Application for a non-material amendment following a grant of planning permission. Town and Country Planning Act 1990

House name: **Dove Cottage**

S.20/1260/HHOLD

Attached drawing 20-0390 D05A shows the approved plans for application S.20/1260/HHOLD. The building work has not yet started. The owner would like the extension roof to be modified as per the attached drawing

Site	Dove Cottage, The Hollies, Nailsworth, Gloucestershire GL6 0AW	Date	23.11.2020
		Sheet	20-0390 D05B
		Scale	As Shown@A1
		Title	As Shown

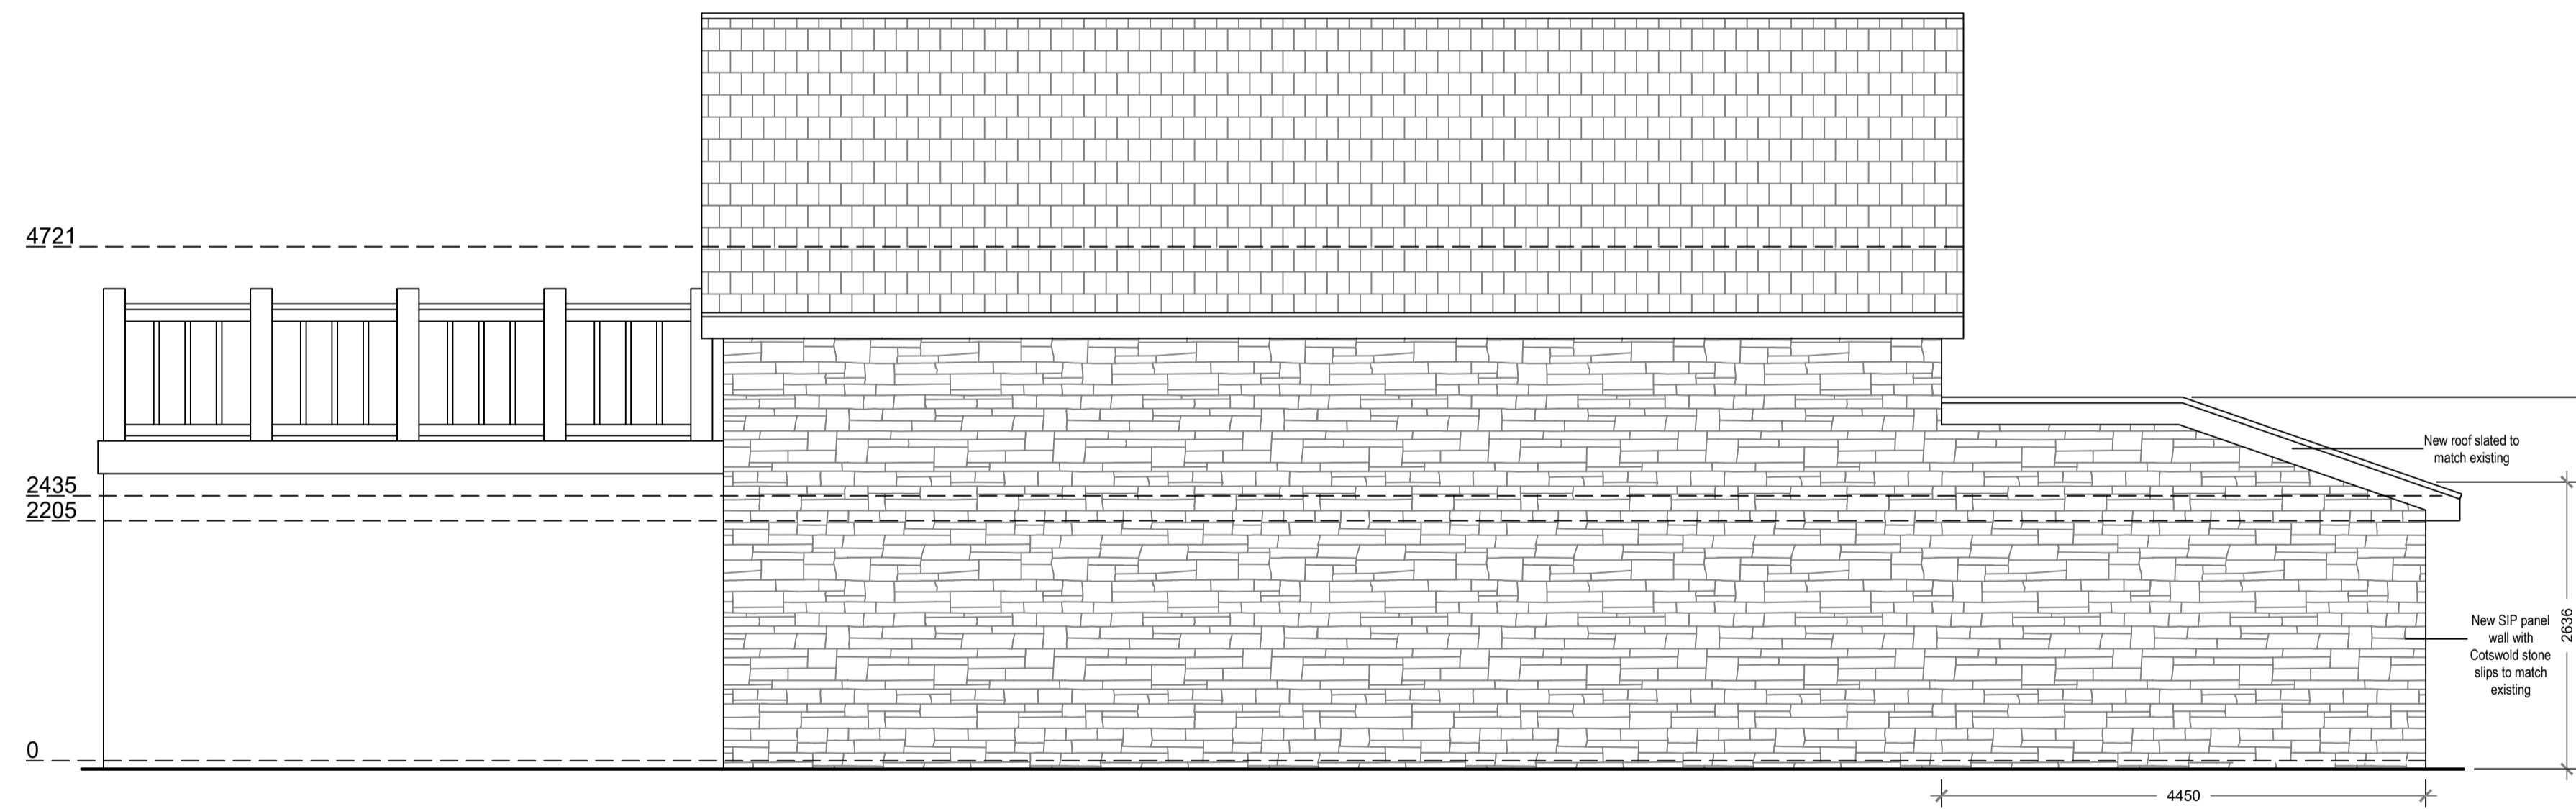
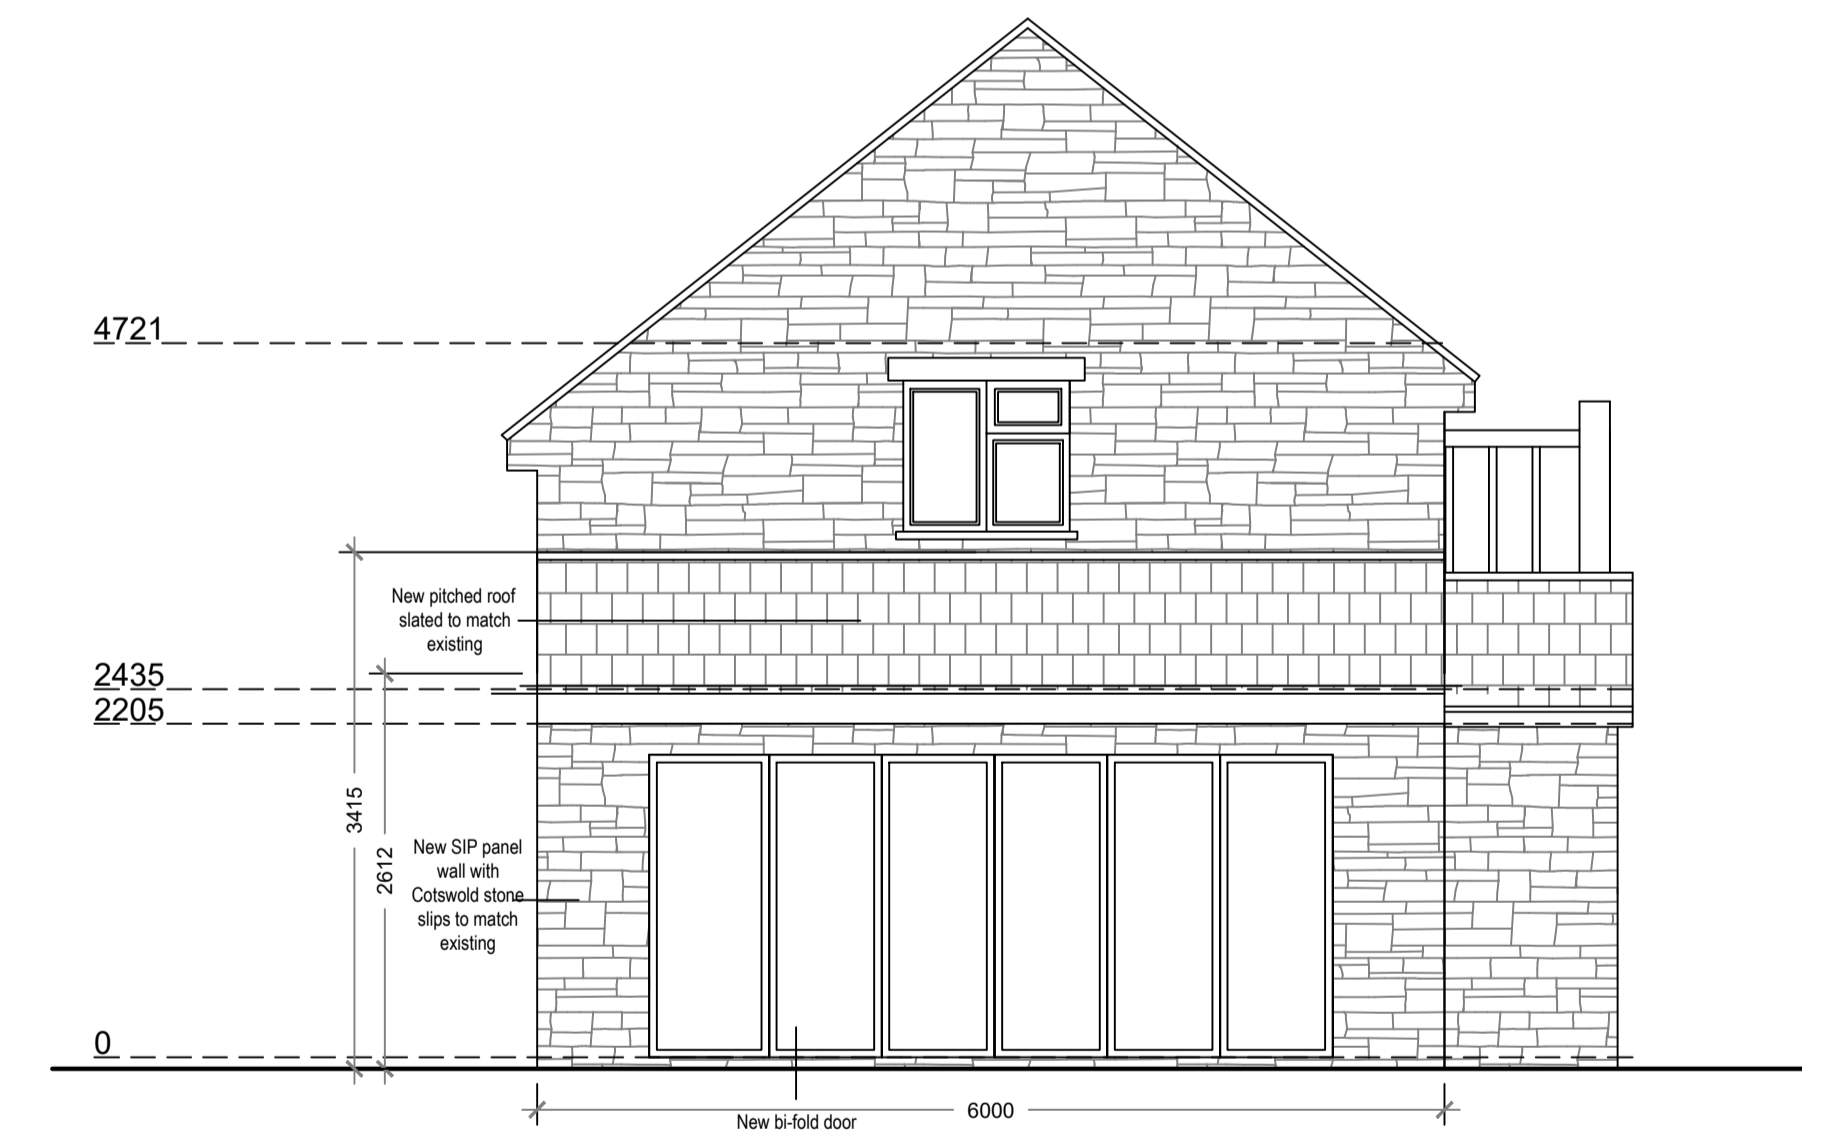
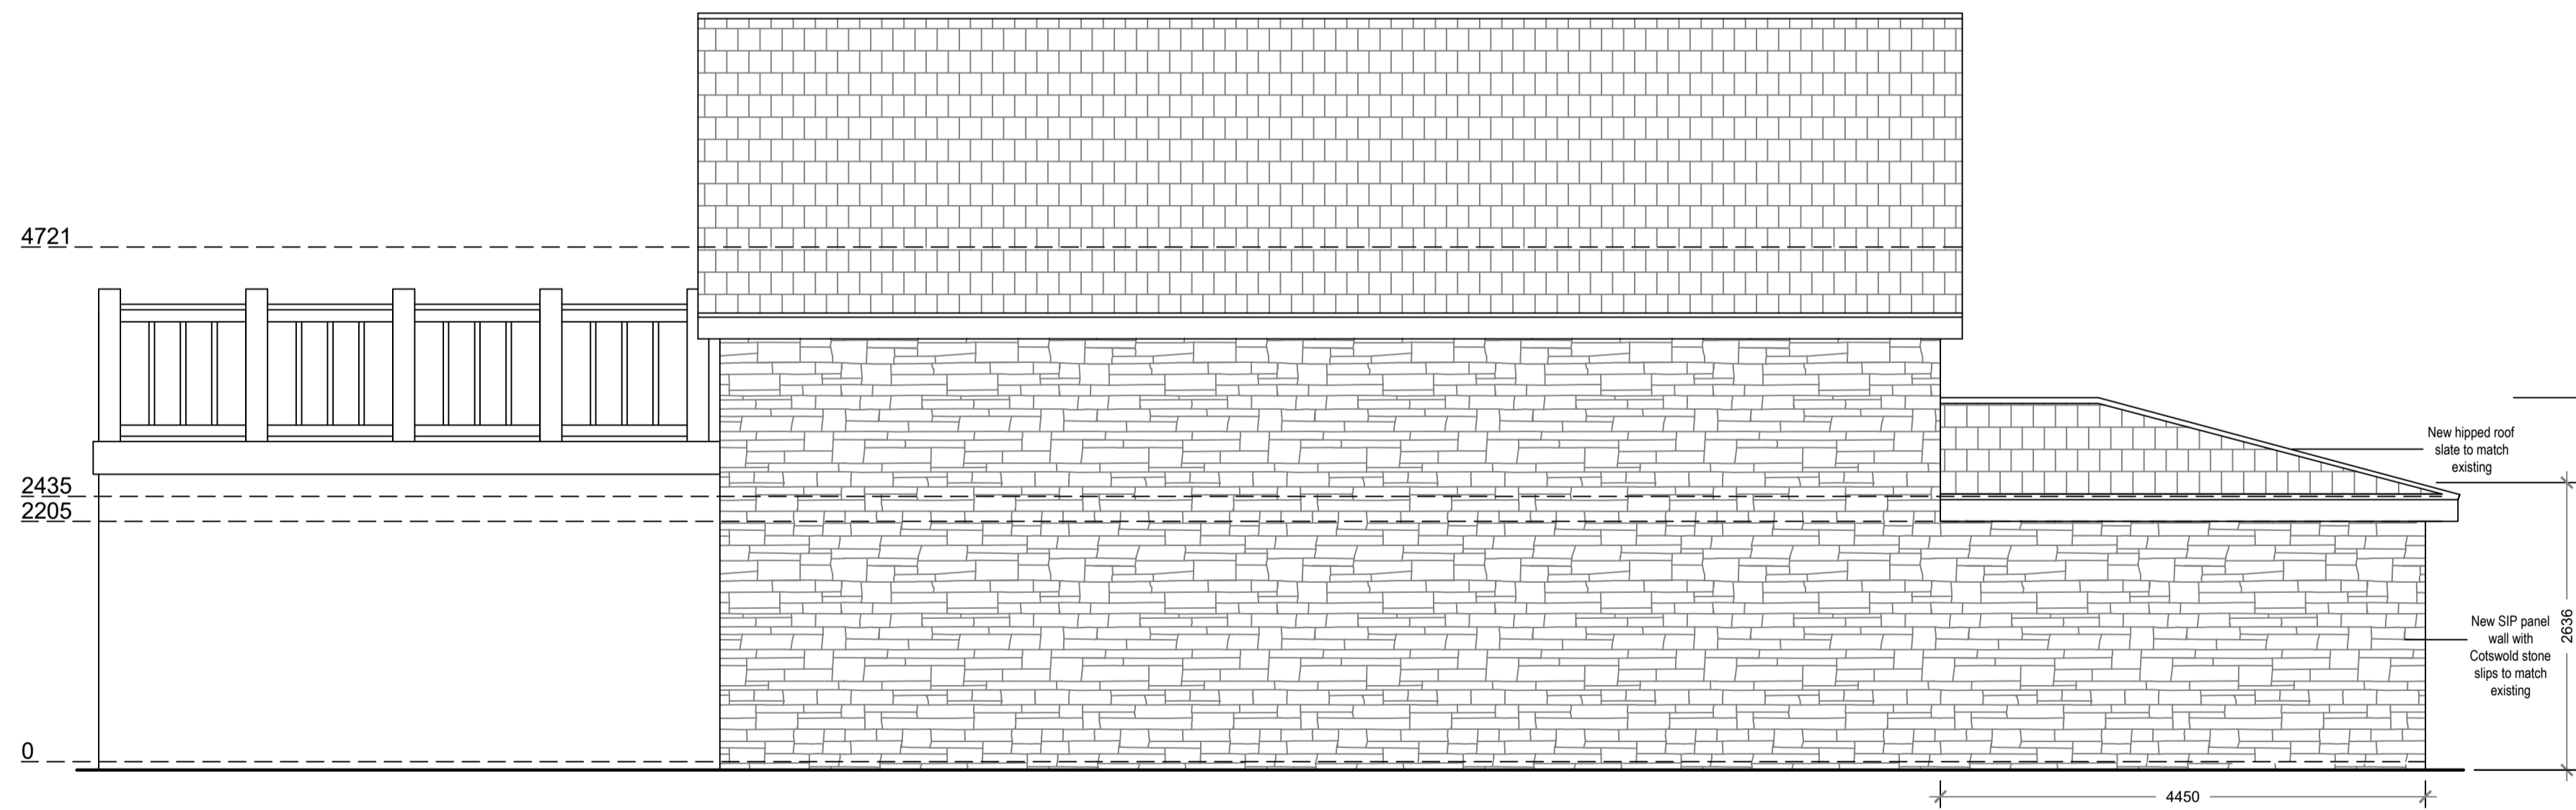
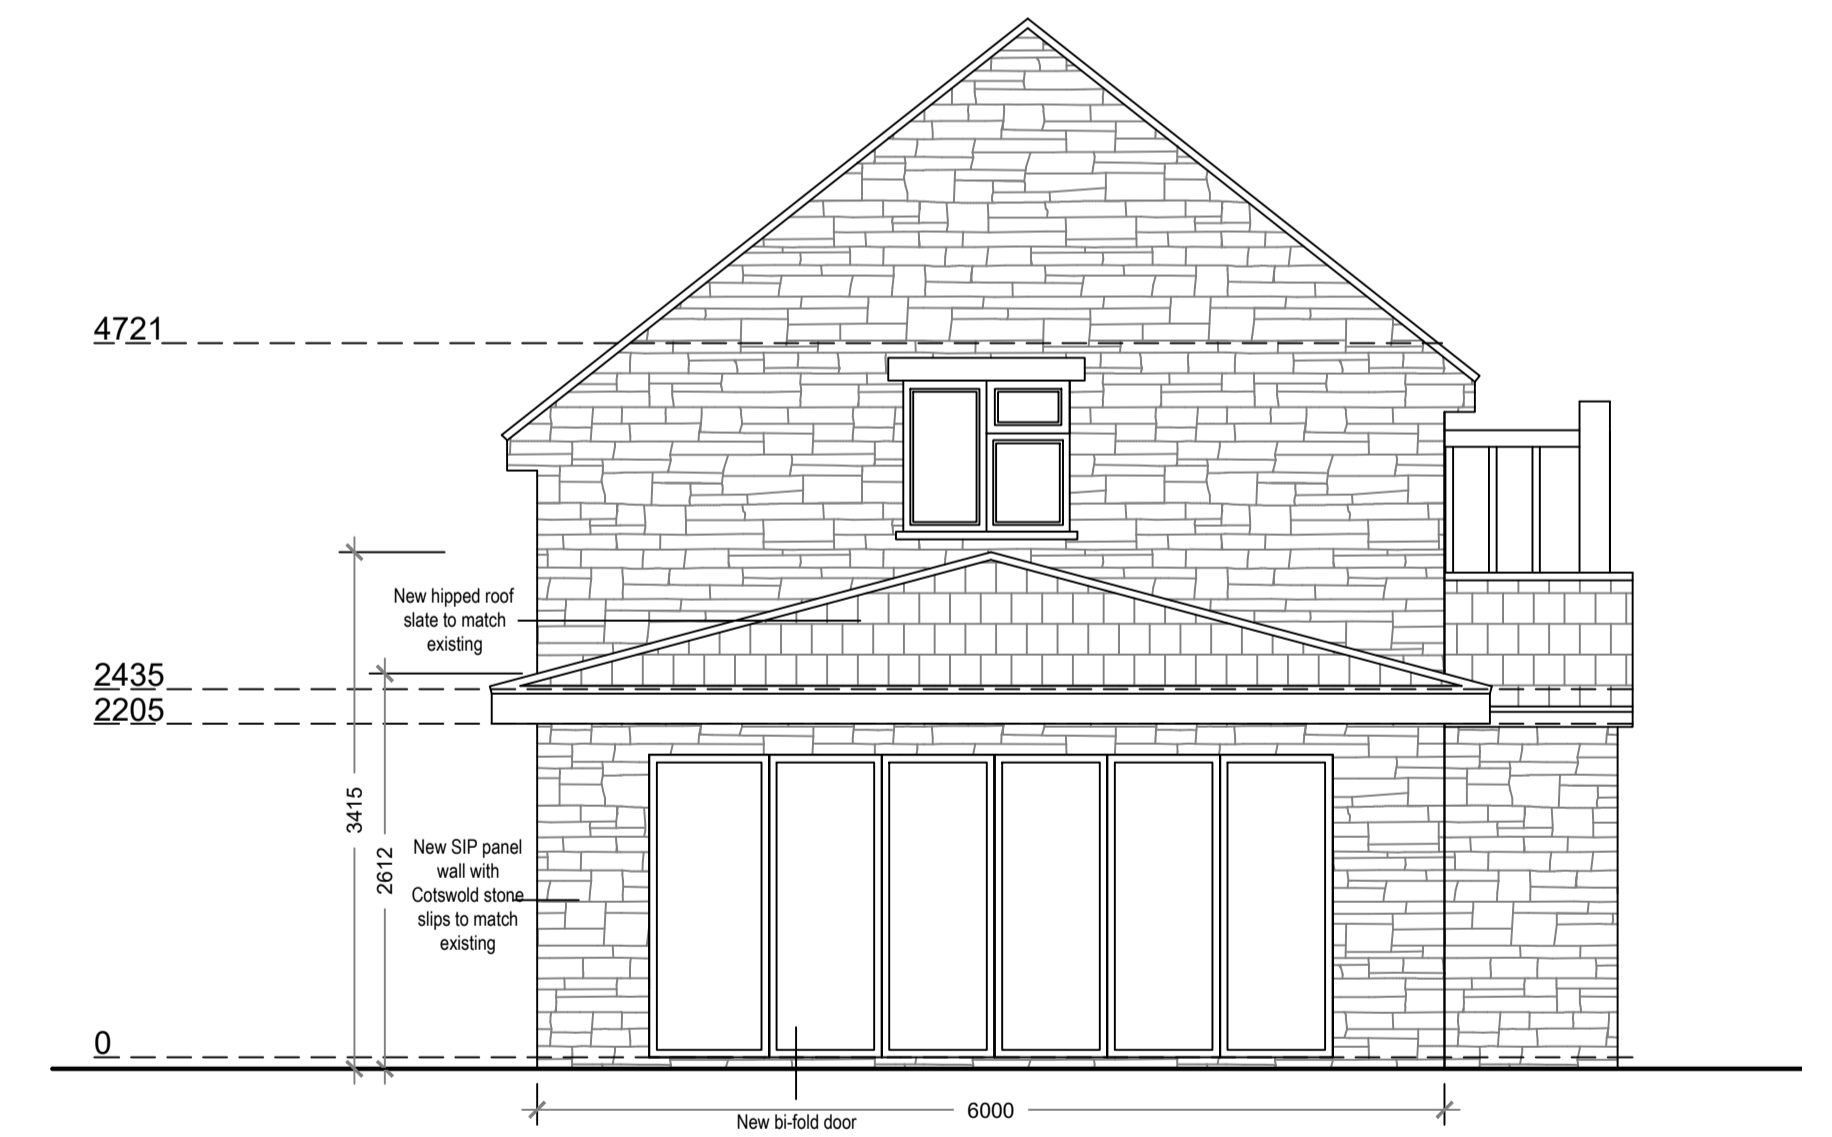
The change is in relation to the roof of the extension which was originally drawn as simple pitch but has now been changed to incorporate a hip.

20-0390 D05B

The owner stated that this revised plan should have been submitted first but the incorrect drawing was submitted in error.
